Our ref: STH19/00029/02
Contact: Melissa Steep 4221 2771
Your ref: SSI 9816

25 March 2019

STATE SIGNIFICANT INFRASTRUCTURE APPLICATION SSI 9816 – GEOTECHNICAL EXPLORATIONS COMPONENT OF THE SHOALHAVEN HYDRO EXPANSION PROJECT

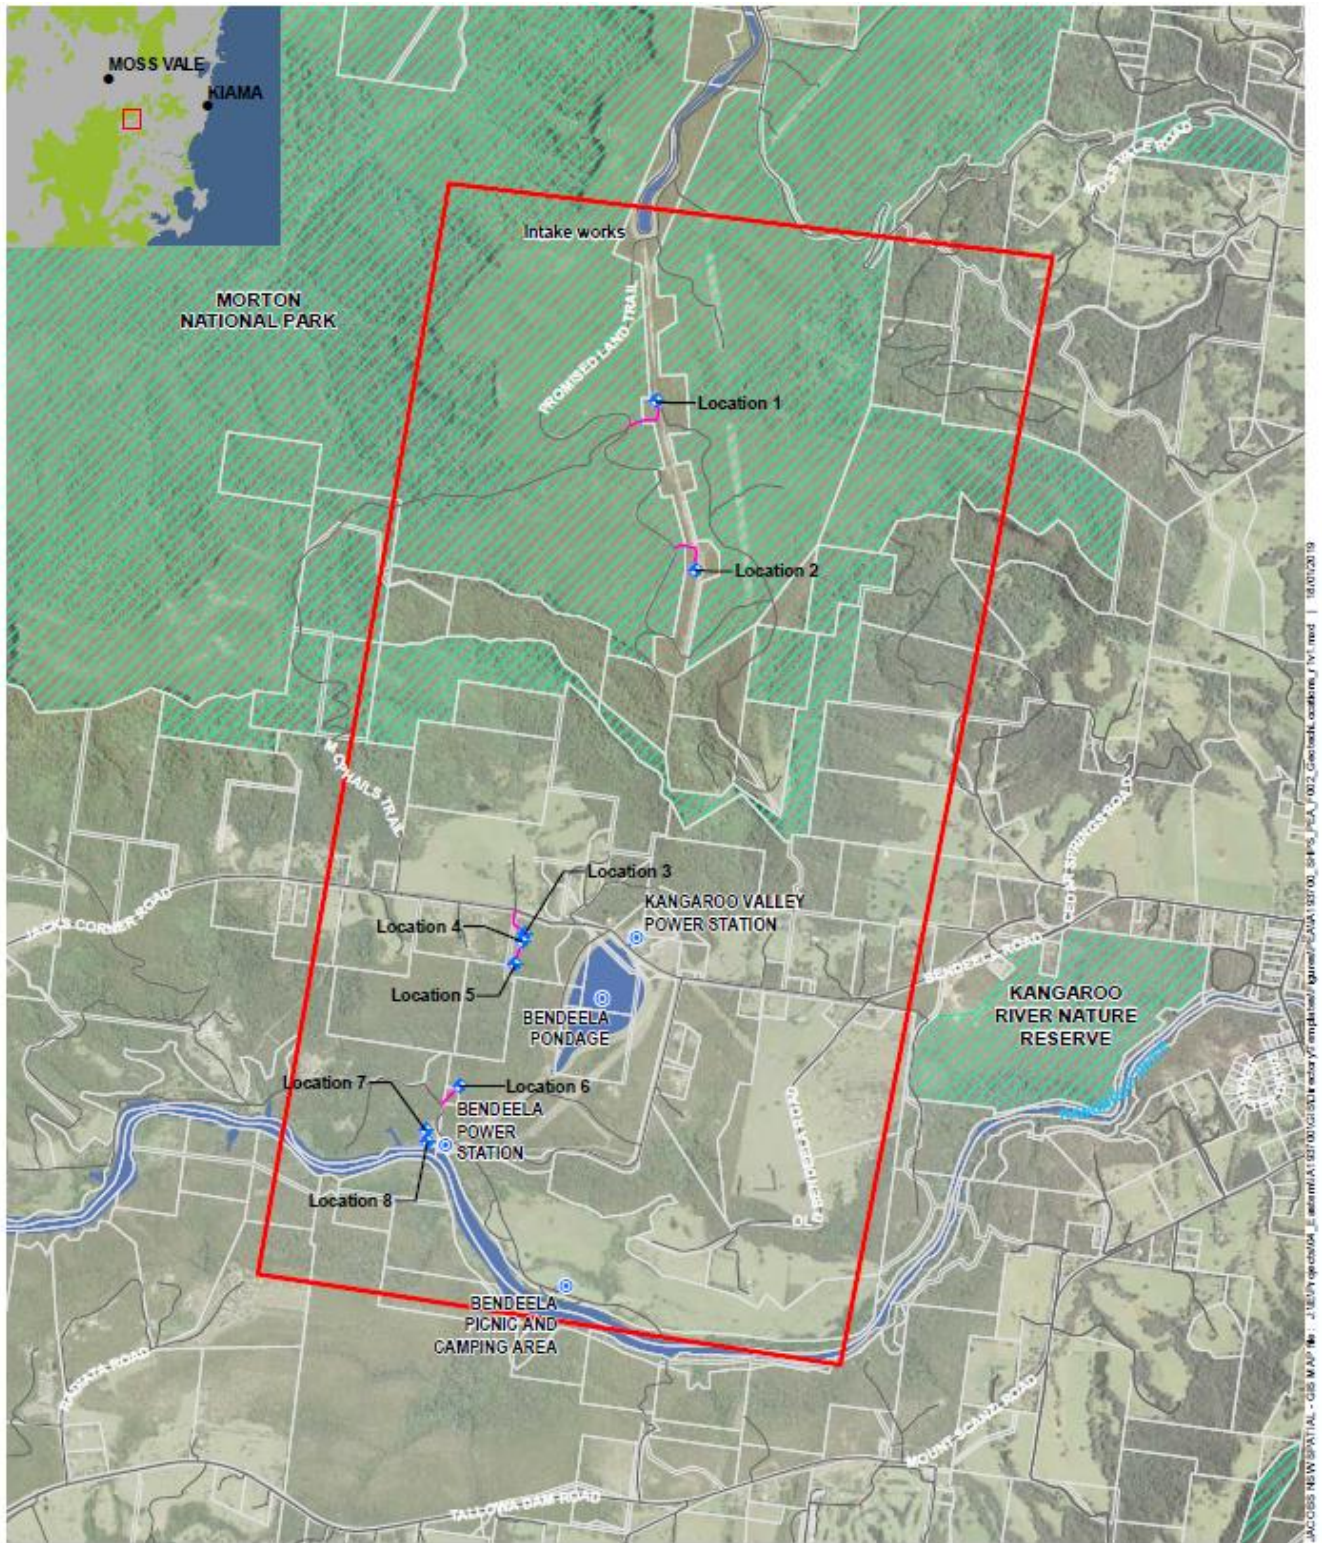
- There is approximately 21m of storage space available at the intersection of Moss Vale Road and the Promised Land Trail.
- Prior to any large vehicle arriving, the site manager will open the gate located on the Promised Land Trail to ensure the heavy vehicle can continue onto the Trail, without needing to store in the abovementioned storage area.

Given the sight distance available at the intersection of Moss Vale Road and the Promised Land Trail is less than the required Safe Intersection Sight Distance (SISD), as outlined in Austroads Guide to Road Design Part 4A, RMS considers a Traffic Management Plan (TCP) should be in place to manage the risks associated with the identified heavy vehicle access at this location.

- A Traffic Management Plan (TMP) to manage the impact of the heavy vehicle accessing the site via the intersection of Moss Vale Road and The Promised Land Trail shall be developed in consultation with RMS Southern Traffic Operations Unit and Council's Local Traffic Committee (LTC). The TMP (and associated Traffic Control Plans) shall be submitted to Council's LTC for final acceptance.

- A copy of the accepted TMP shall be forwarded to RMS (via development.southern@rms.nsw.gov.au) prior to any transportation occurring or works commencing on site for this development
